Australian Hearing Hub – Response to Submissions

Project Application (MP 10_0032)

Turning Path
10.8m Garbage Truck

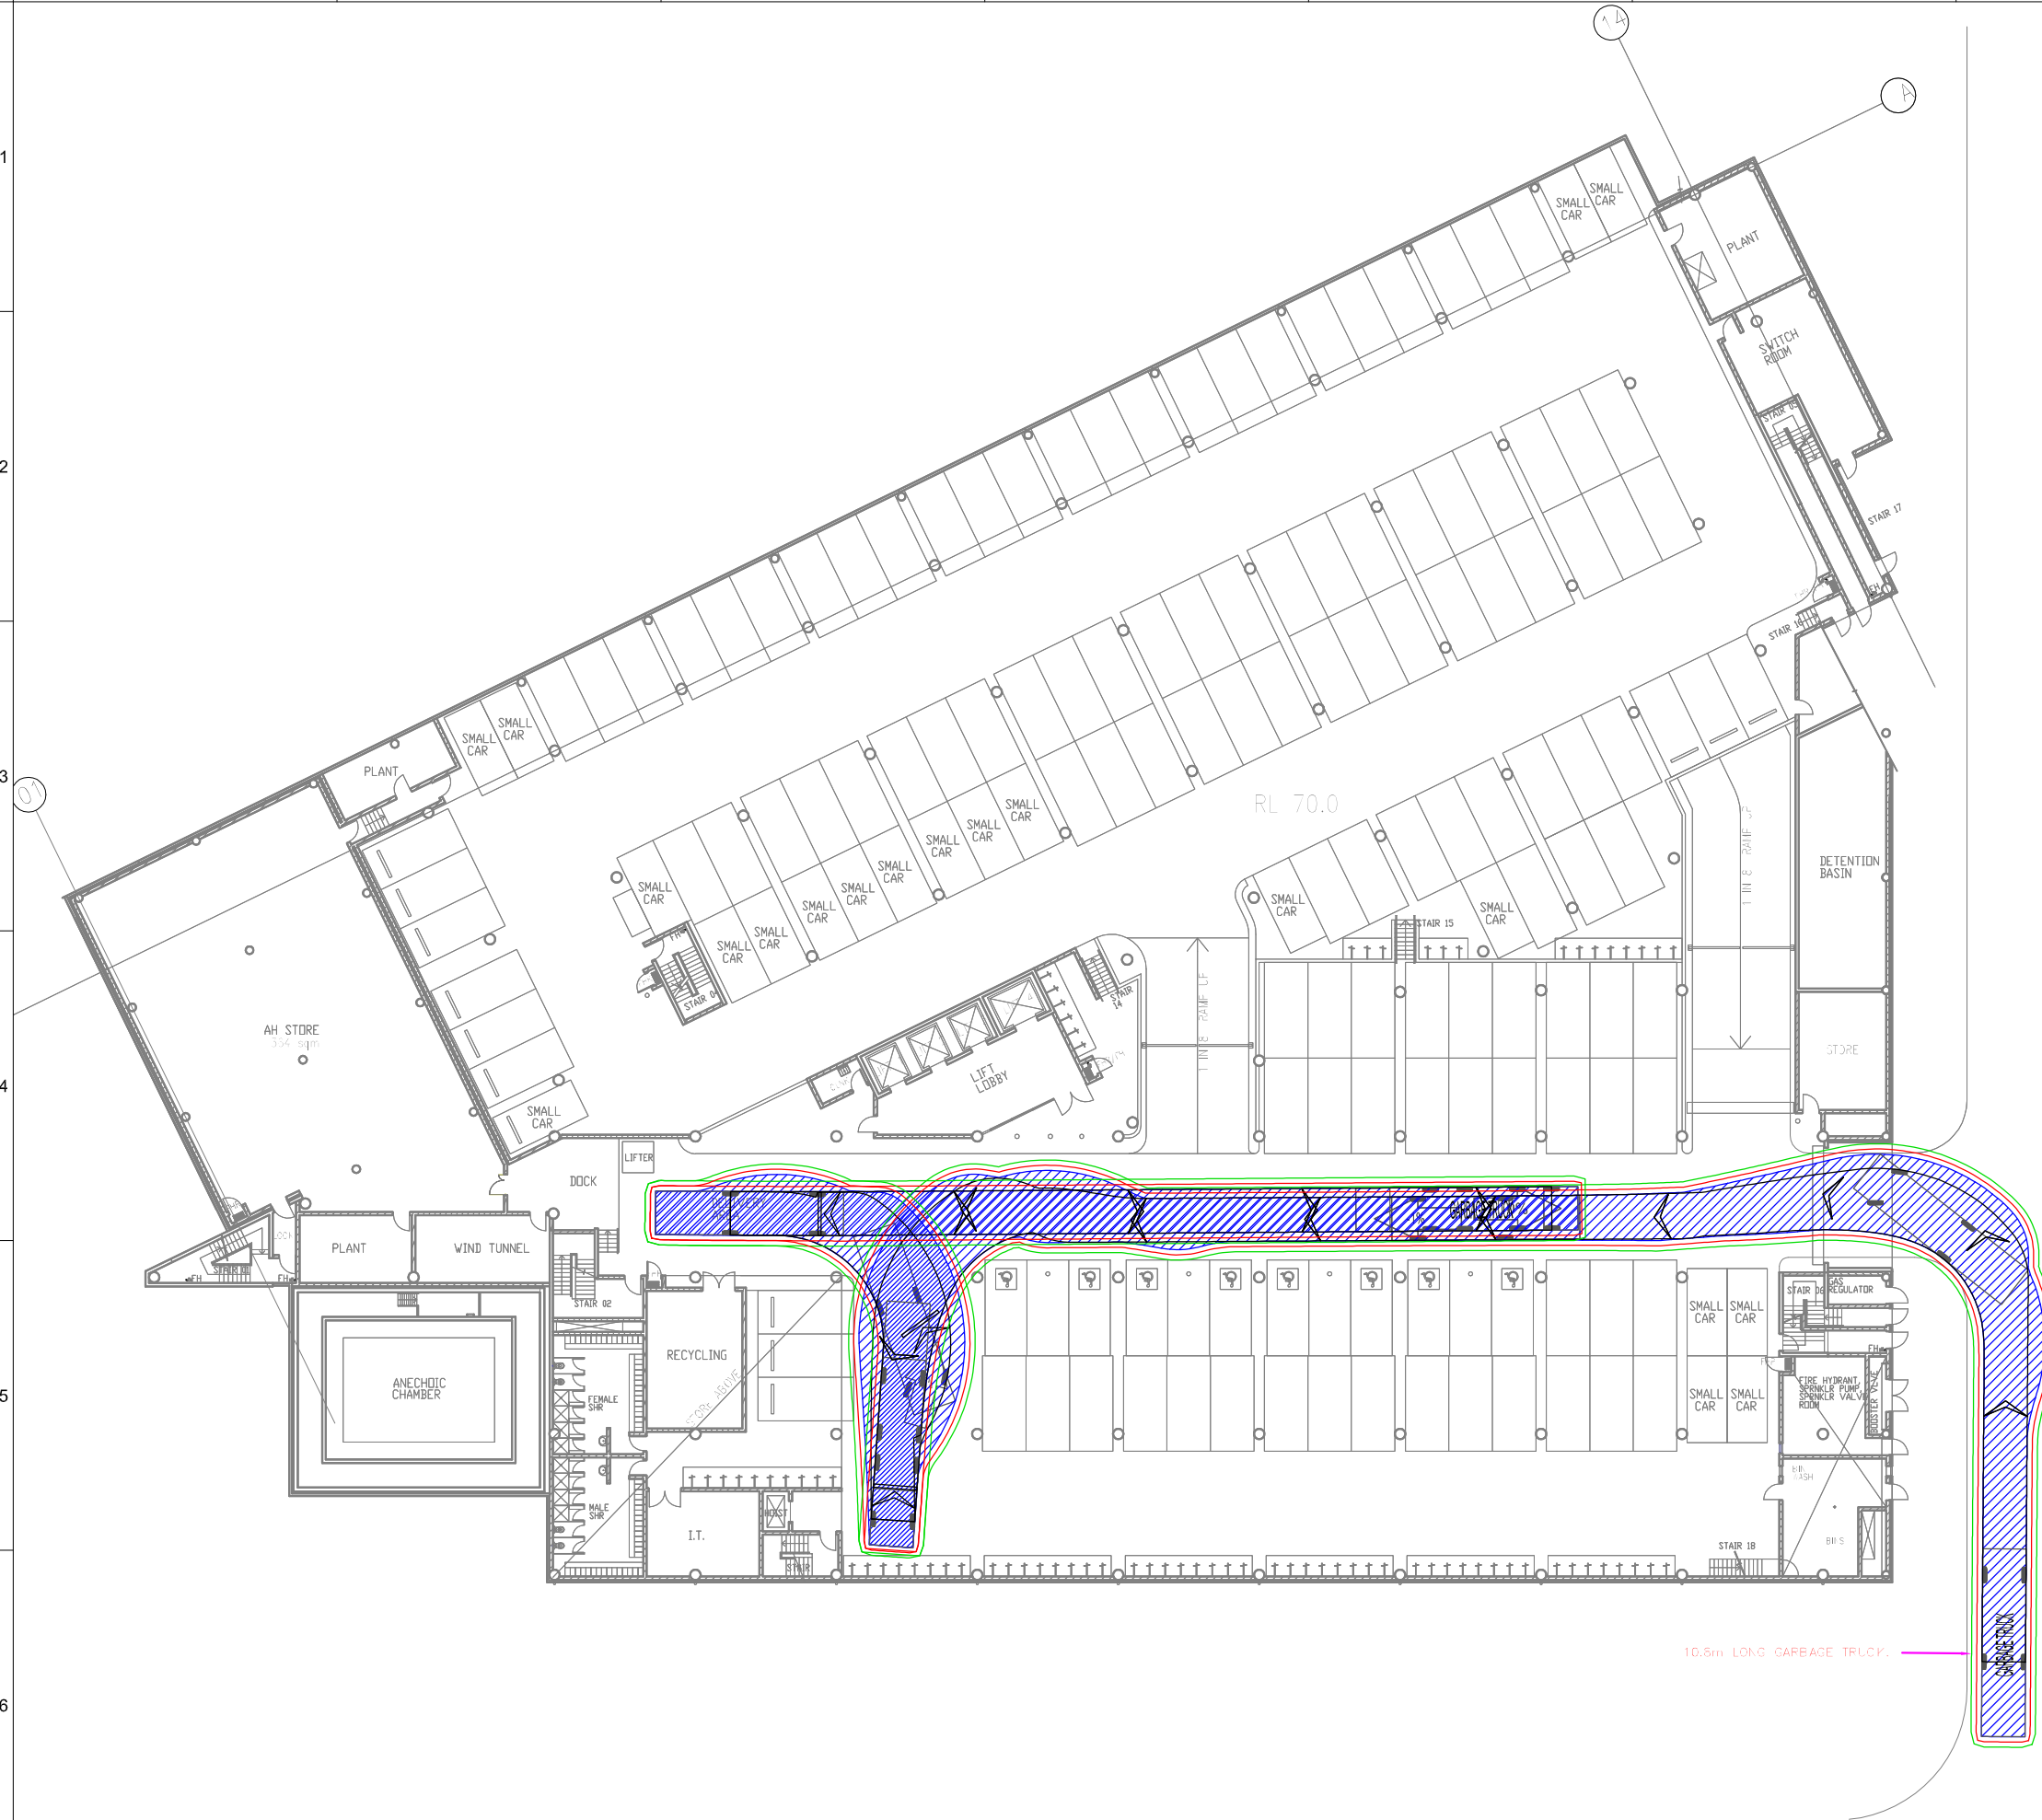
| 7 | The layout of the proposed car parking area associated with subject development should be in accordance with AS 2890.1-2004 and AS2890.2 – 2002 for heavy vehicles and servicing. | The layout of the proposed car park has been designed in accordance with AS 2890.1-2004 and AS2890.2 – 2002. The Statement of Commitments has been updated to reflect this matter. Additionally Woolacotts has provided written confirmation (see Attachment G) that these standards can be complied to. |

NORTH WEST ELEVATION

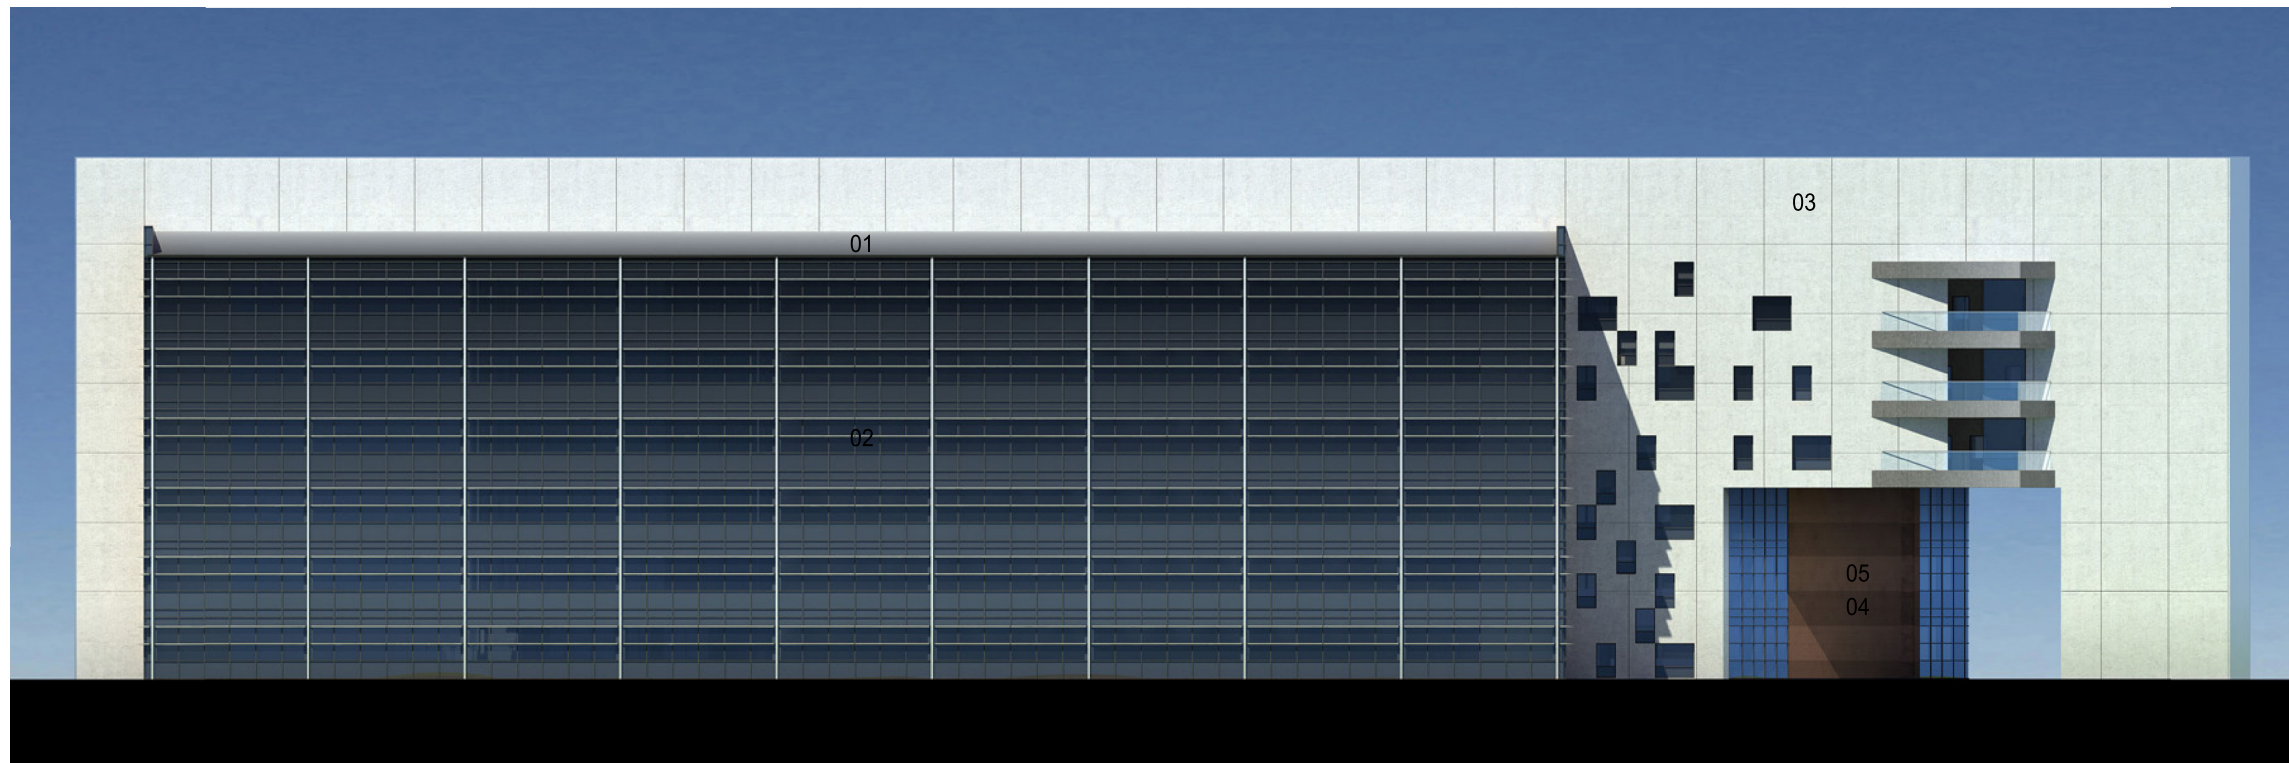
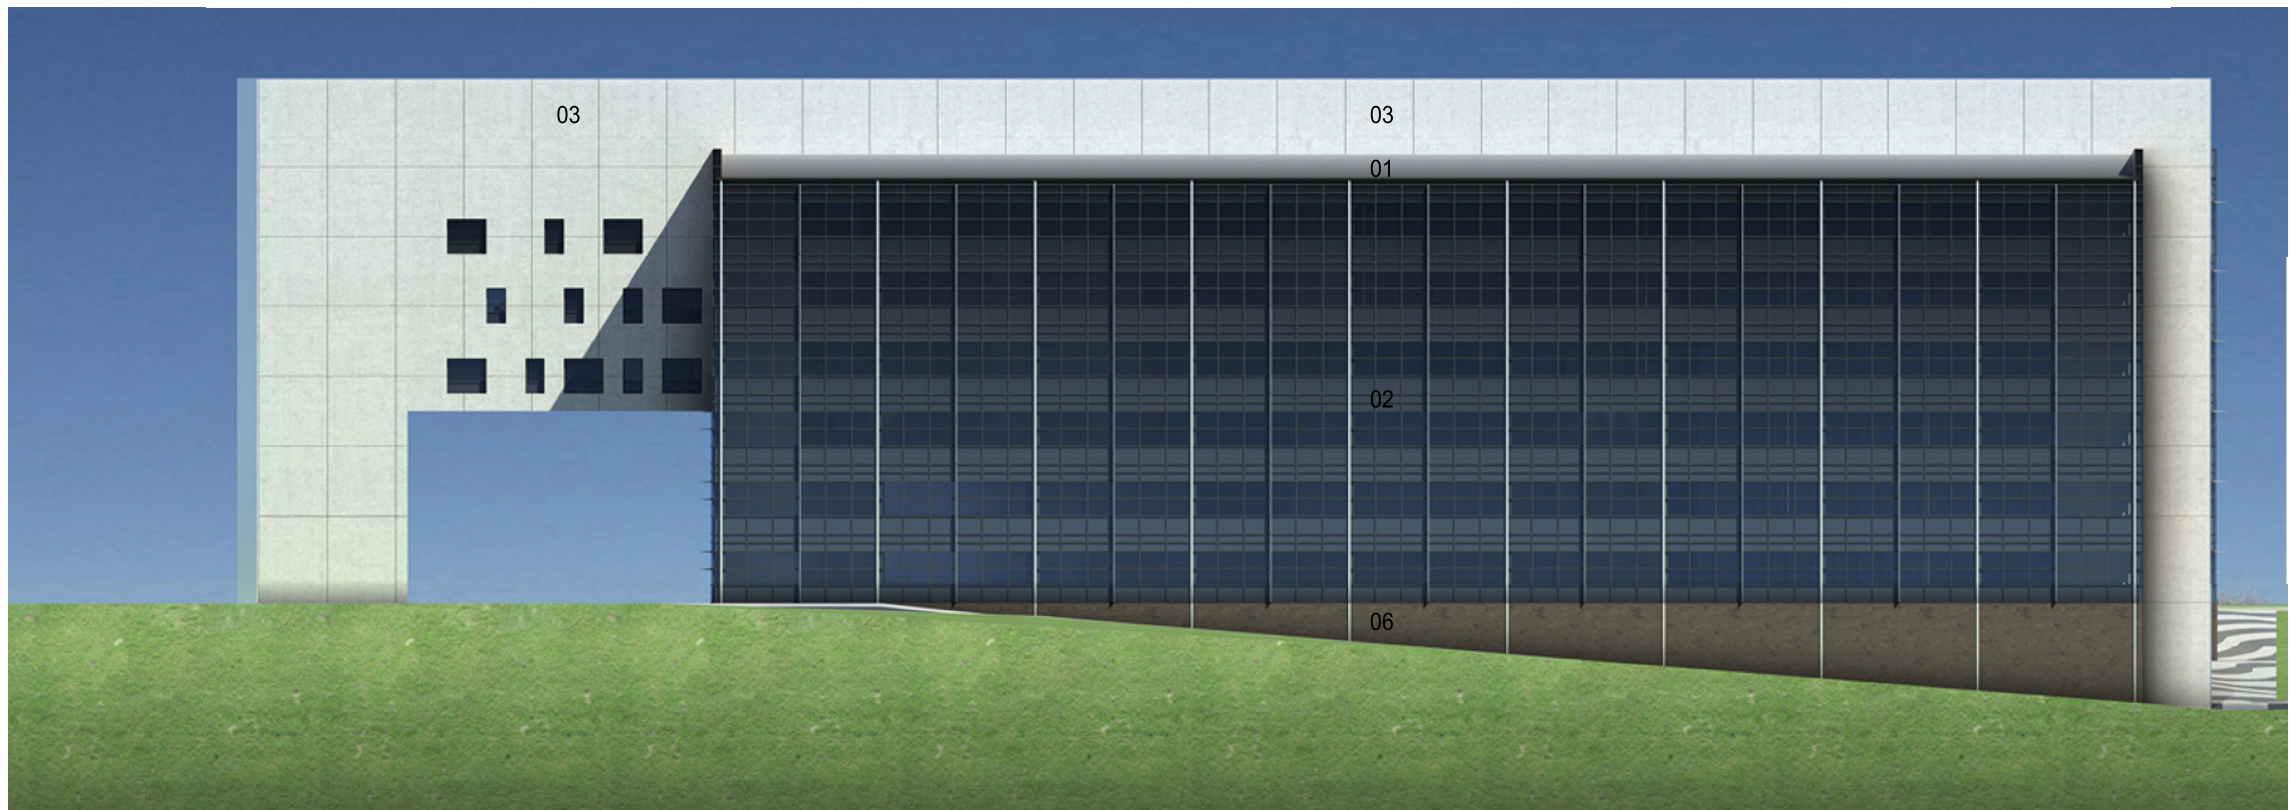
| 9 | The articulation of the façade needs to be developed further. <ul style="list-style-type: none"> - This includes better definition of the top and base of the building. - Stronger articulation of the elevations. | The proponent is not making any revisions to the design of the façade which was prepared in accordance with the Precinct E Precinct Plan. The proposal is considered to have sufficient articulation in keeping with the design concept for the Hearing Hub to create a V-shaped building with two 'wings'. |
| 11 | It is recommended that large, high areas of blank solid wall be minimised. | Noted. The areas of blank solid wall have been minimised in the design of the building and where possible activation has been provided at ground level. However, as a result of the topography of the site, a small section of the basement on the southern side of the building protrudes out of the ground. As this wall screens the car park and it is not possible to provide activation of this part of the building, we are of the opinion that it is a better planning outcome to provide a high quality face brick finish than views into the basement car park. |
